From: Jonathan Best <Jonathan.Best@arun.gov.uk>
Sent: 05 May 2026 09:59
To: Planning.Responses <Planning.Responses@arun.gov.uk>
Cc: Neil Crowther <Neil.Crowther@arun.gov.uk>
Subject: A/44/26/PL

Former Shrublands Nursery Roundstone Nursery Angmering BN13 4AT.

Recommendation: I recommend holding this application until further details are provided on bird and bat boxes.

Sigma Homes
scheme: Former Shrubland Nursery, Angmering
client: Sigma Homes
drawing: Soft Landscape Proposals
date: February 2021
scale: 1:200@A1
drawing no: PR123161 11_A
drawn: JO checked: DKM

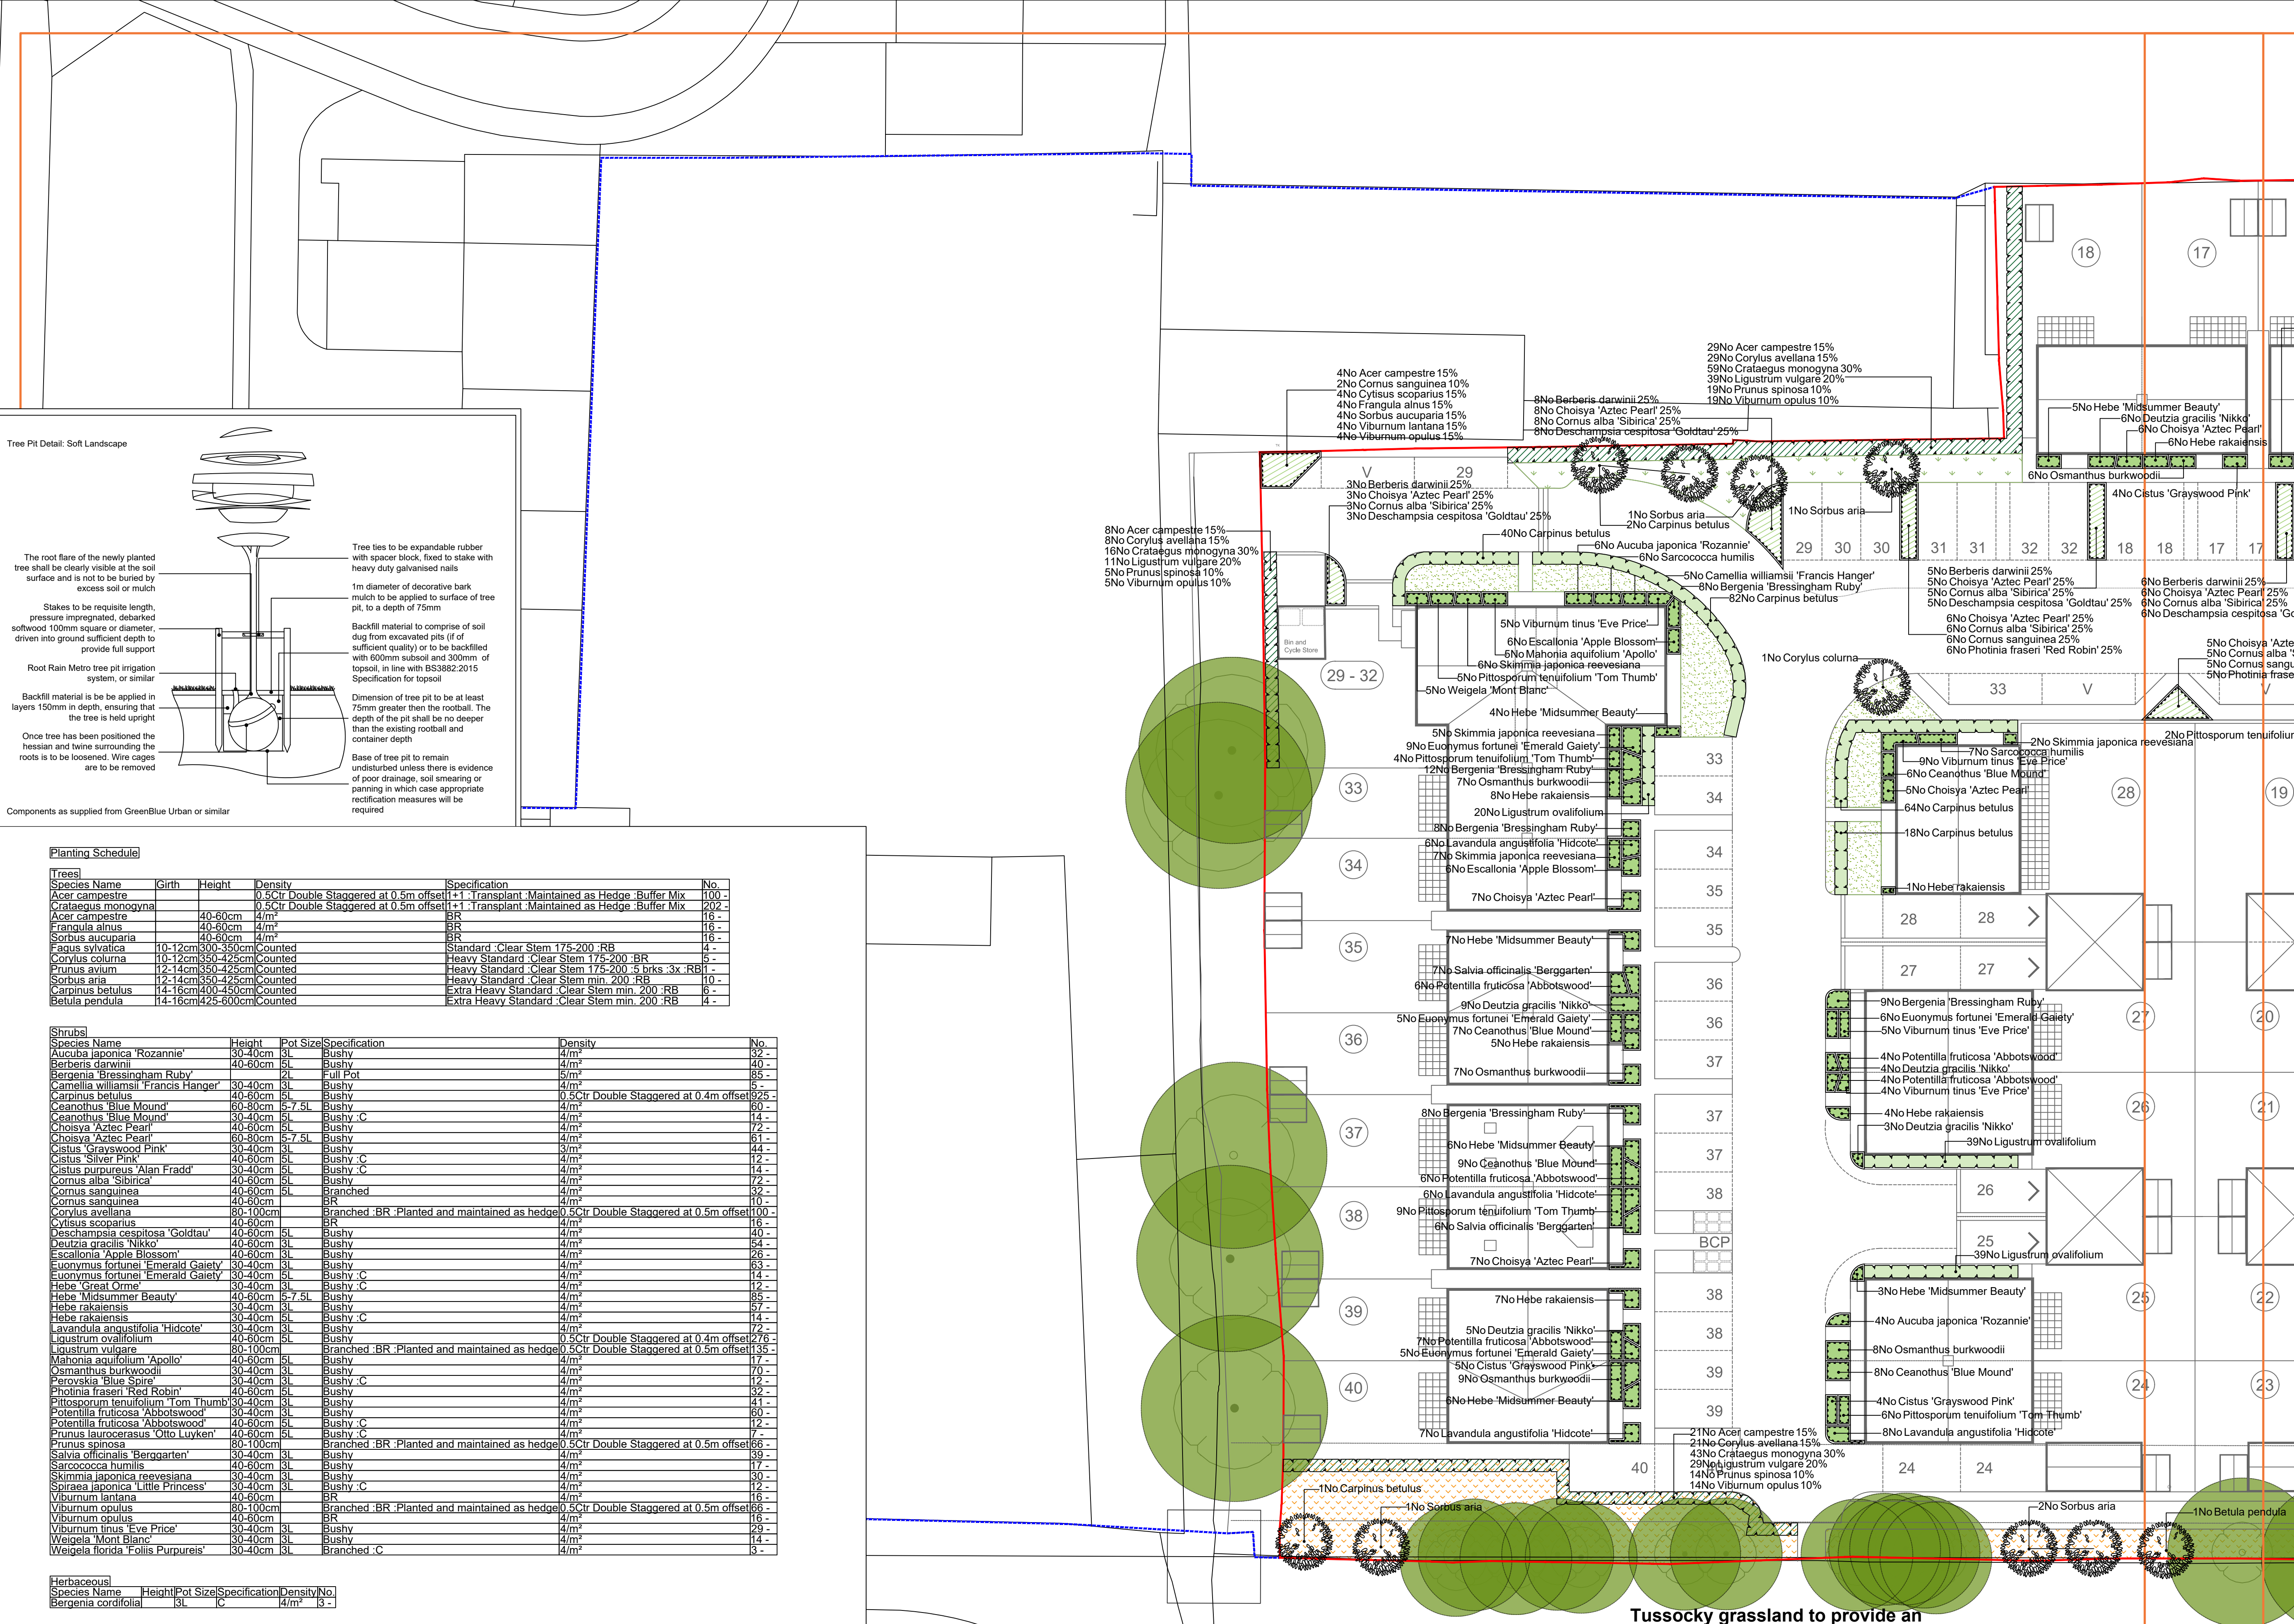
The proposed native tree and hedge planting is acceptable.
